PEACEFUL RIDGE AT FOUNTAIN VALLEY SUBDIVISION

RESIDENTIAL SUBDIVISION CONSTRUCTION DRAWINGS

EPC STORMWATER REVIEW COMMENTS ARE SHOWN IN ORANGE BOXES WITH BLACK TEXT

KNUCKLE #1 - SLEEPY MEADOWS DRIVE & PEACEFUL RIDGE DRIVE

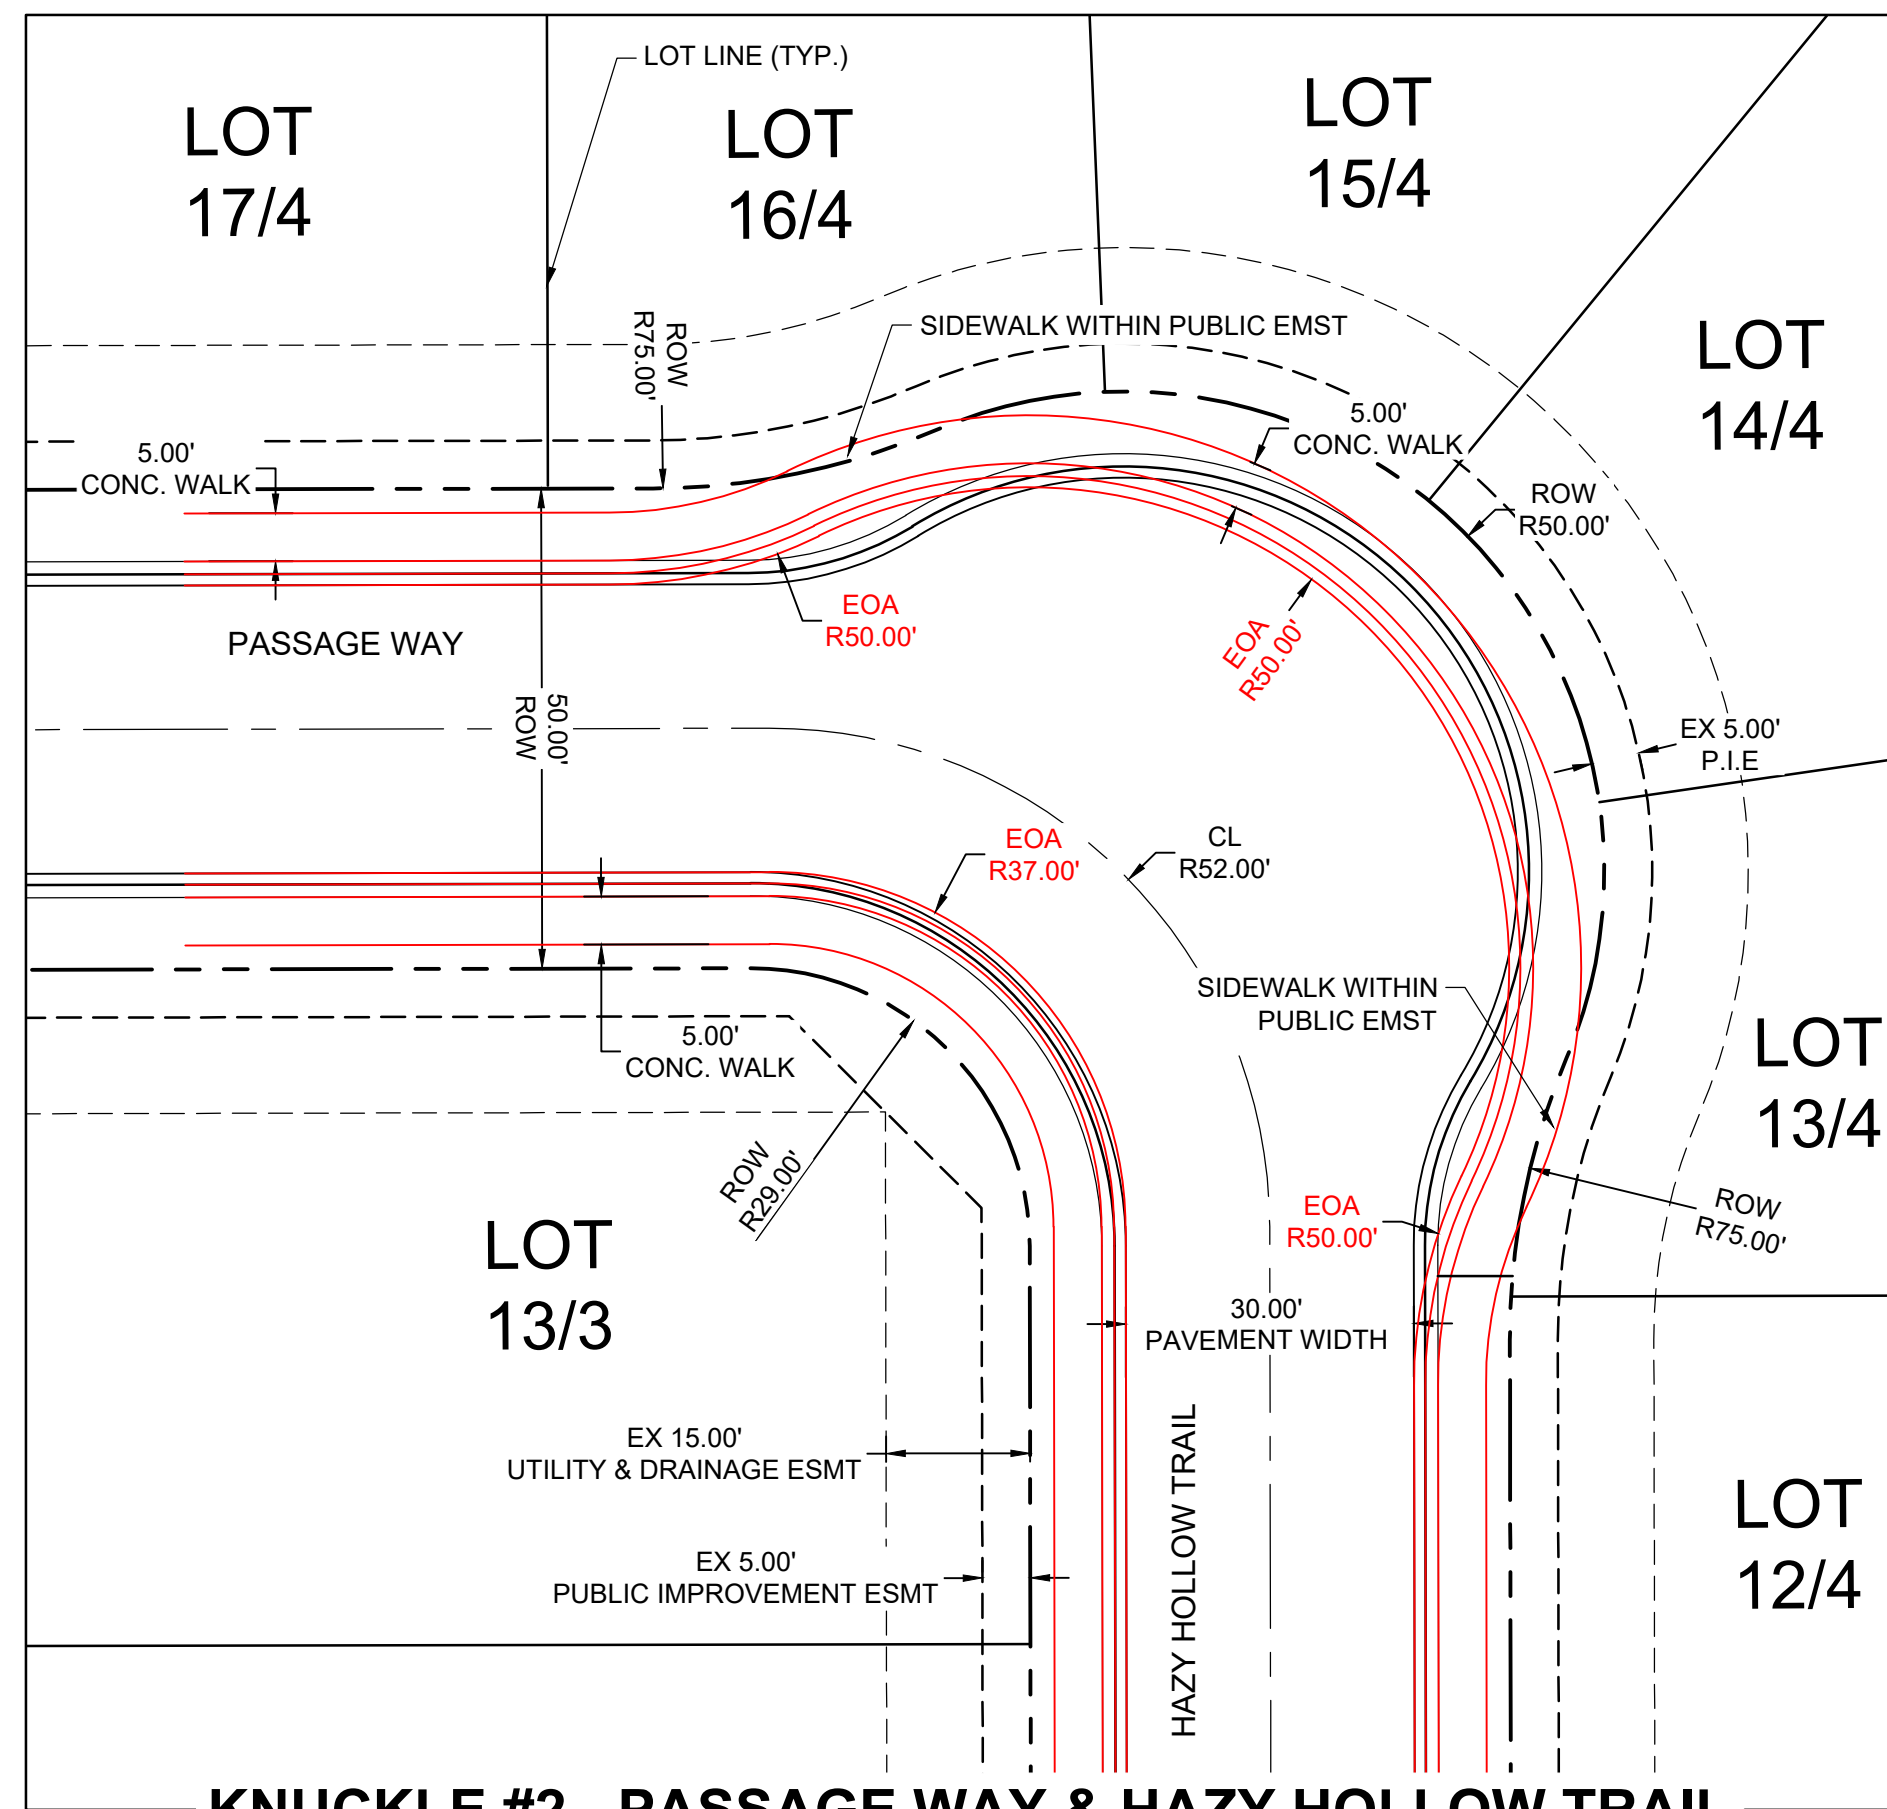
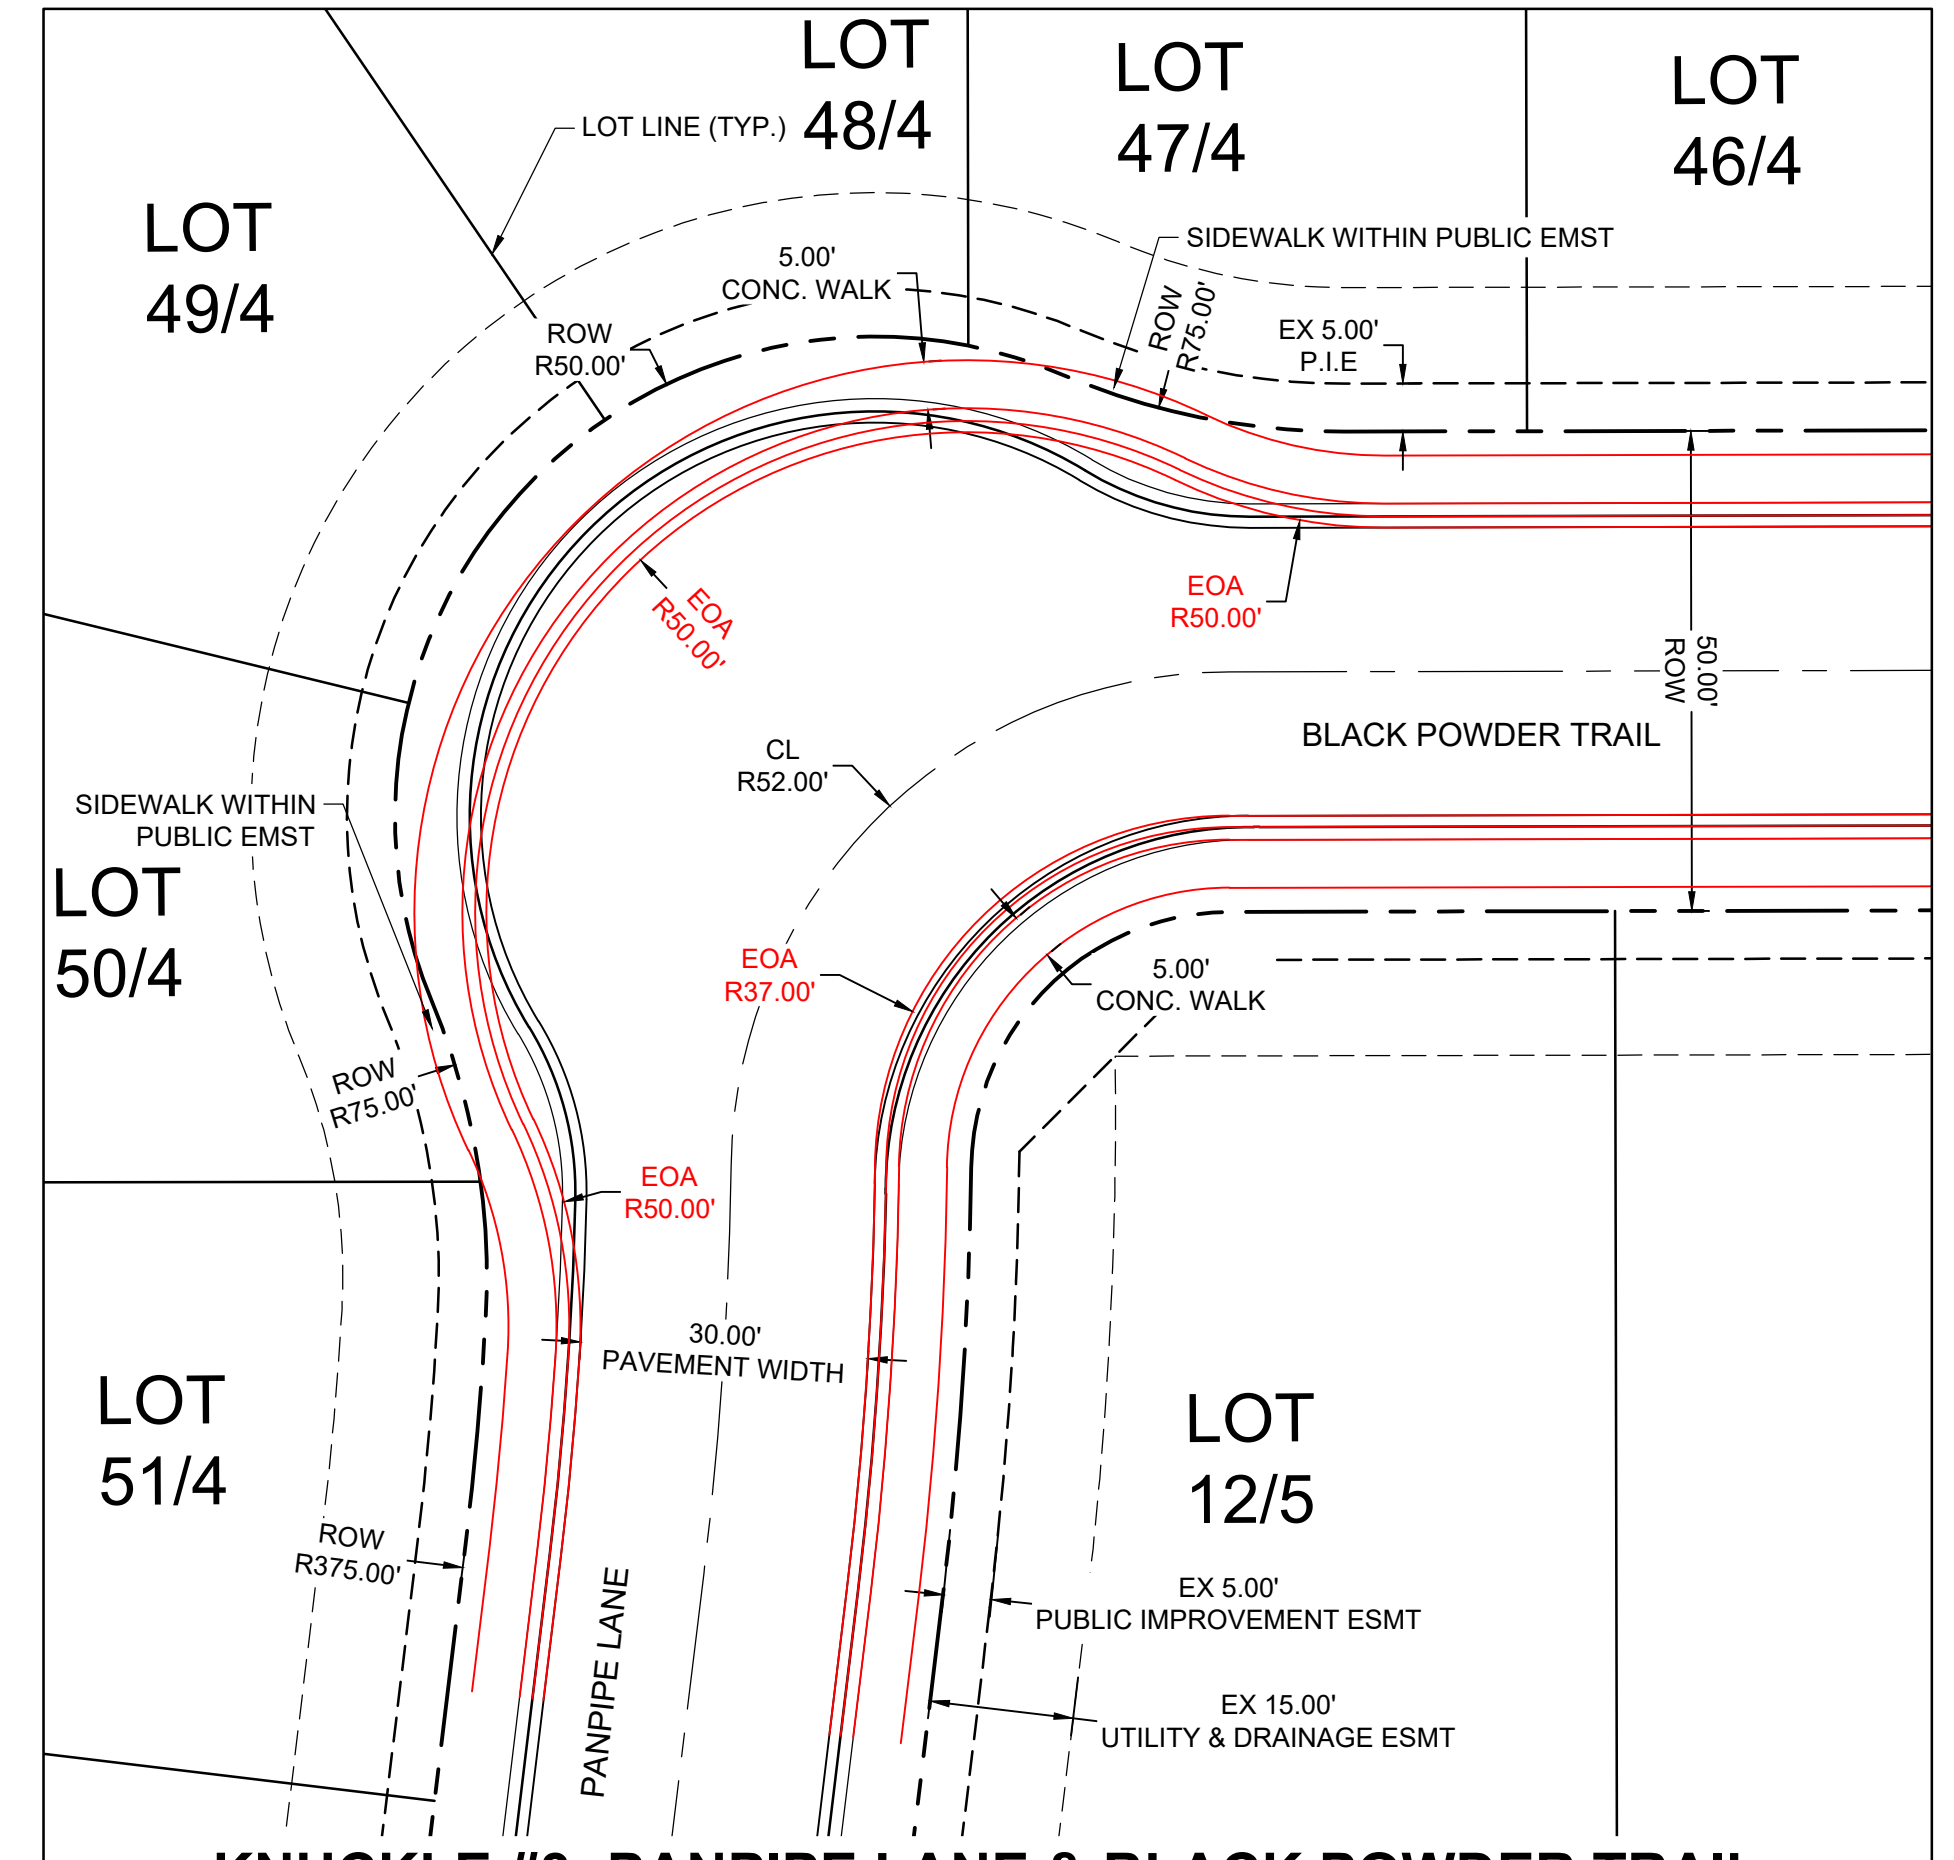
Knuckle designs do not meet EPC SD-2.77, please submit deviation requests for knuckles for documentation.

5D and 5E are not shown in the legend. A deviation request is required for the knuckle design not meeting ECM criteria.
